## **Ecology Comments**

**Date: 07/03/2025**

**Address: Land at Ford Airfield**

**F/14/24/RES: Approval of reserved matters (layout, scale, appearance and landscaping) following outline consent F/4/20/OUT for the infrastructure reserved matters including the provision of a primary spine road and associated secondary road junctions, pavement, footpaths, cycle infrastructure and bus stops; site wide drainage infrastructure including foul pumping stations, foul sewer infrastructure, SUDS basins, SUDS swales, surface water infrastructure; acoustic fencing; public open space including landscape details, play areas, footpaths & associated works. This application affects a Public Right of Way, may affect the setting of a Listed Building and falls within CIL Zone 1 (Ford strategic site - zero rated).**

Figure 1 ... Hibernacula design.

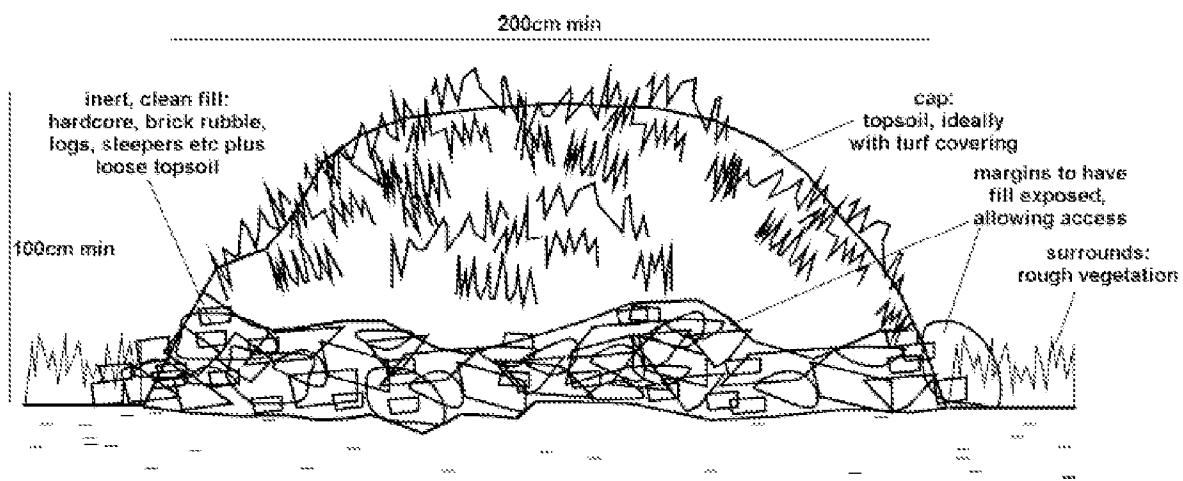
5 no. hibernacula and 9 log piles are being provided across the site (within IRM F/14/24/RES) which will help both reptiles and amphibians, and is acceptable. The Hibernacula specification provided within the Ecological Protection and Enhancement Plan should be conditioned.

Appendix 1 – Landscape design and biodiversity enhancements

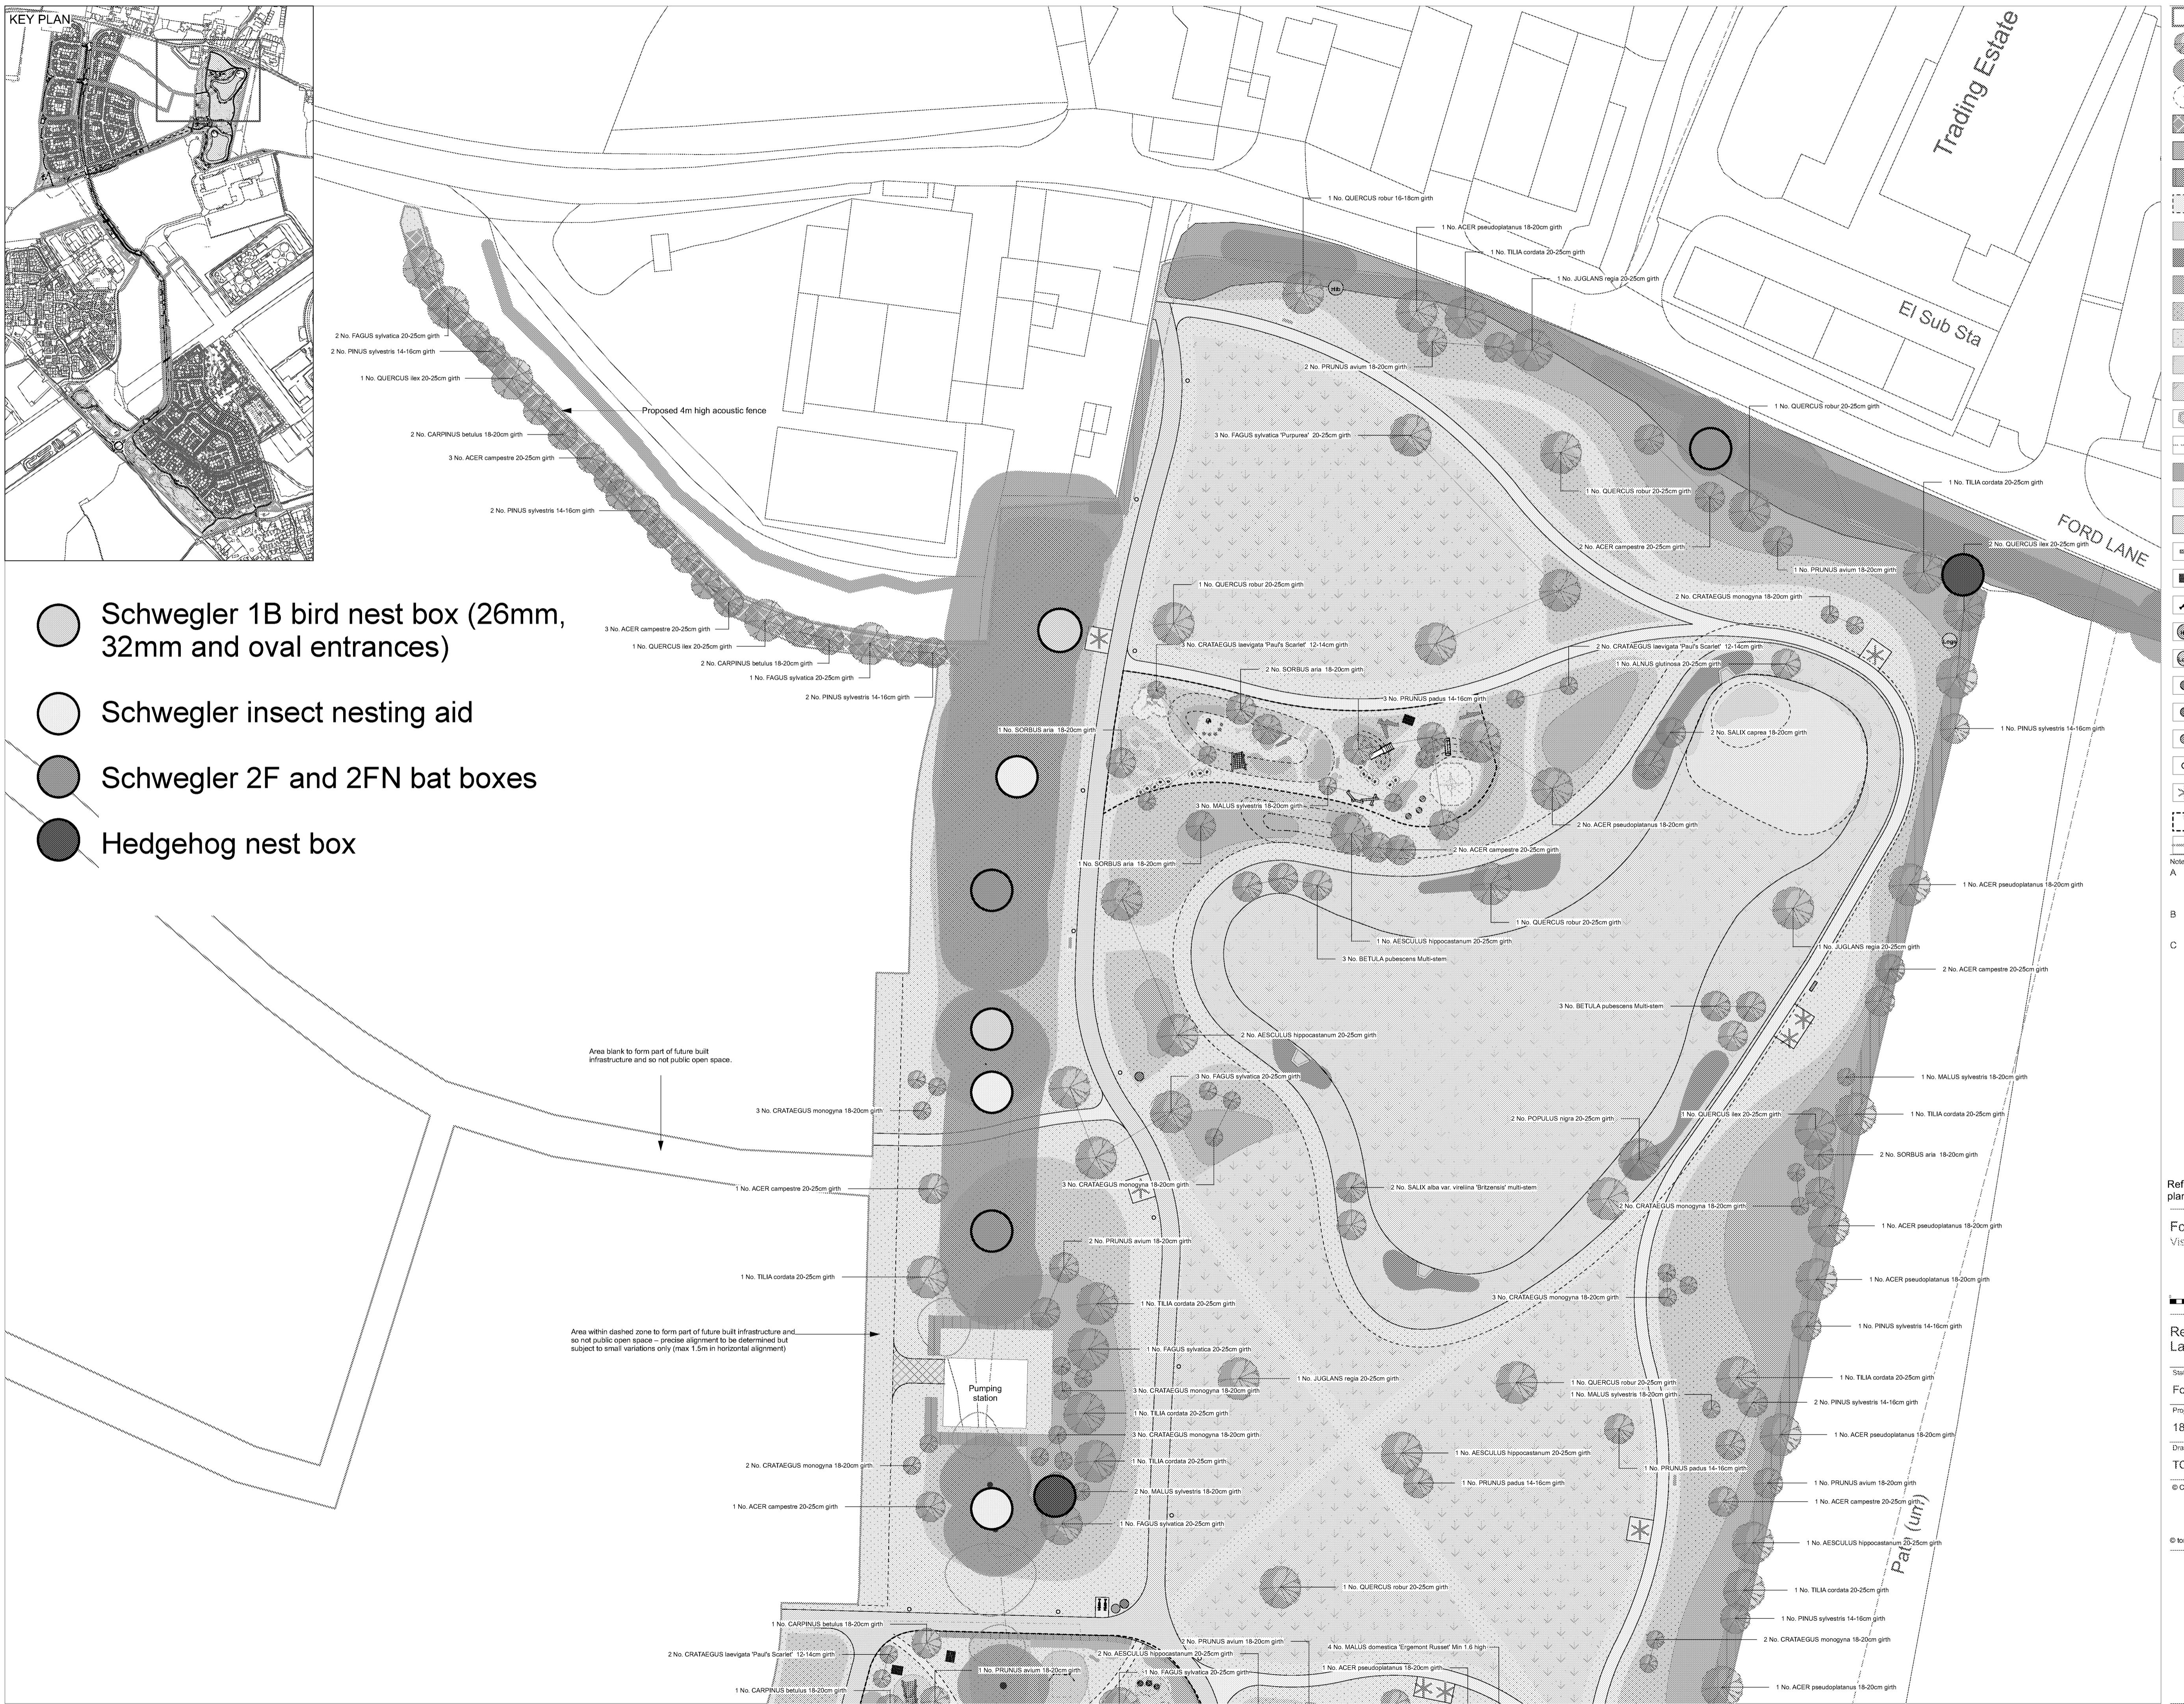
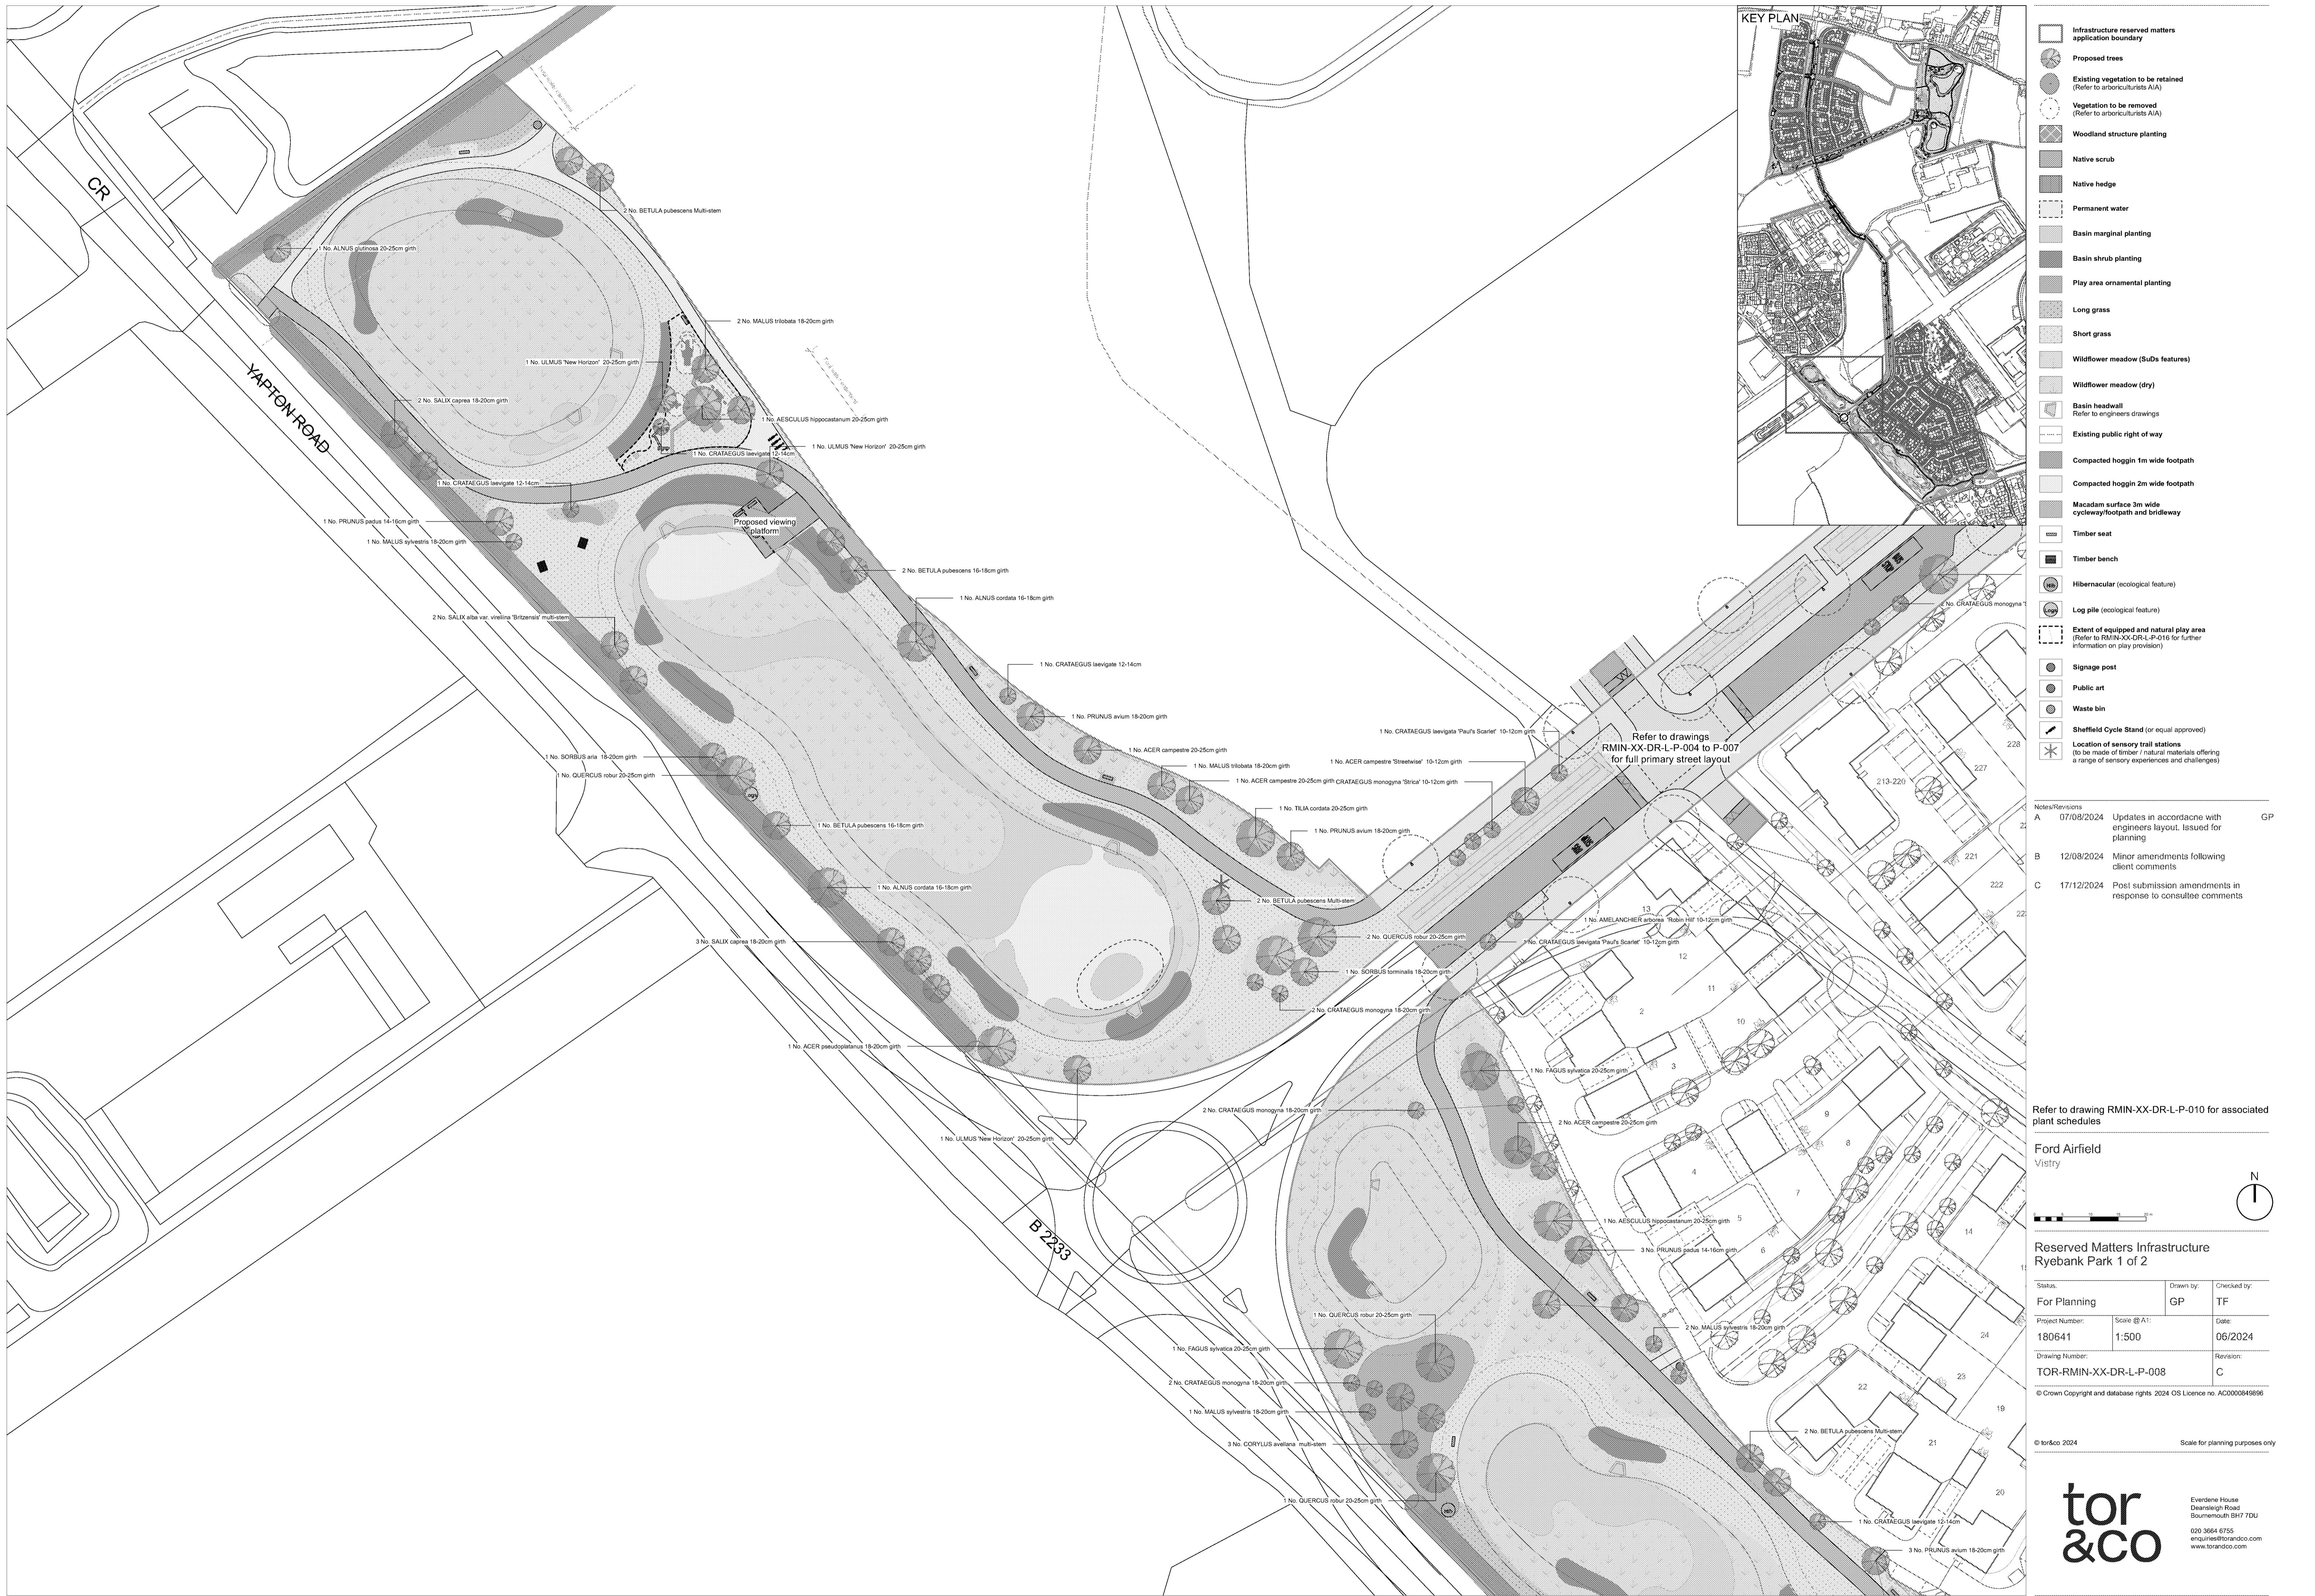
Larger hibernation boxes could be installed on established trees and woodland within the site. The open space included within IRM, for example along the Arun Way and in the Landings Green could incorporate additional external bat boxes.

These bird boxes are acceptable; however, the plans provided do not provide a breakdown of how many boxes of each are to be provided. Given the universal nature of swift boxes, these should be prioritised.

12no. Schwegler Insect Nesting Aid (insect houses) are proposed to be fitted to semi-mature / mature trees which are due to be retained within the proposed development site (within application F/14/24/RES). The locations for the proposed insect boxes are acceptable. However, the locations are primarily within the northern section of the site, and as a result more freestanding insect boxes should be included within areas without existing mature trees.

In addition, hedgehogs nest boxes have been identified in terms of their number and location, which is acceptable, but no specification has been provided. This could be adequately conditioned.
